RE: Status of Improvement Permit Application #3-5-5839
Lots 14 & 15 #3-5-5844

On November 18, 2002, an Environmental Health Specialist from the Harnett County Health Department attempted to evaluate your property for the purpose of issuing an Improvement Permit. This individual was unable to evaluate your property for one or more of the following reasons.

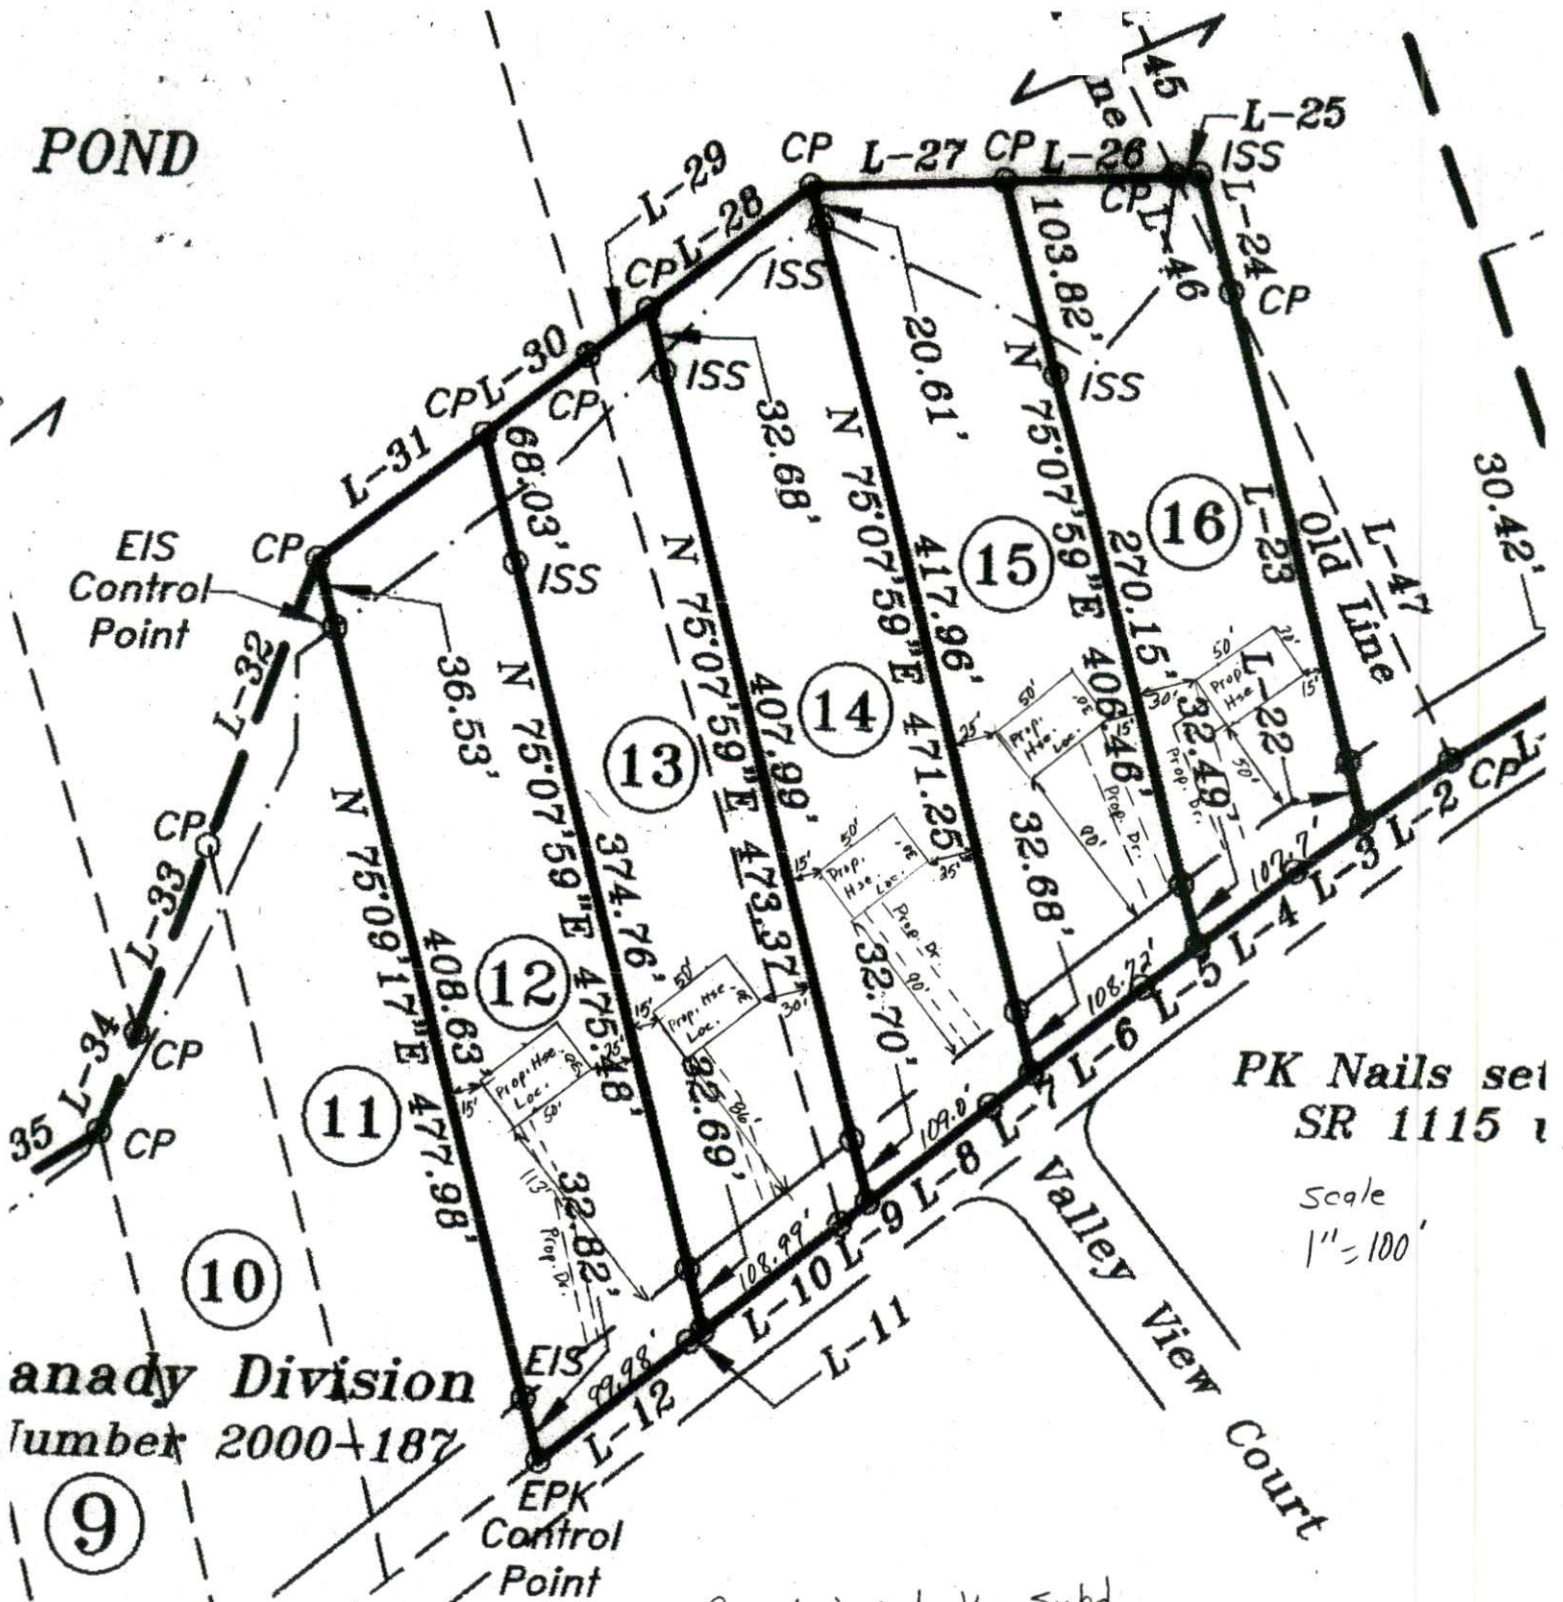
- 1. Property lines/corners not marked or labeled
- 2. House corners not marked or labeled
- 3. Directions not clear to property
- 4. Property needs brush or vegetation removed
- 5. Backhoe pits required
- 6. Other **What is staked on the ground does not match map submitted. Property lines and lot numbers also do not match. Please contact me so we can get things either mapped right, or staked correctly. *Note there are three other lots not yet confirmed, lots #12, #13 #16 which appear to have the same problem.**

When you have completed #6, please call 910-893-7547 to confirm that the items mentioned have been corrected, we will then reschedule your property for evaluation.
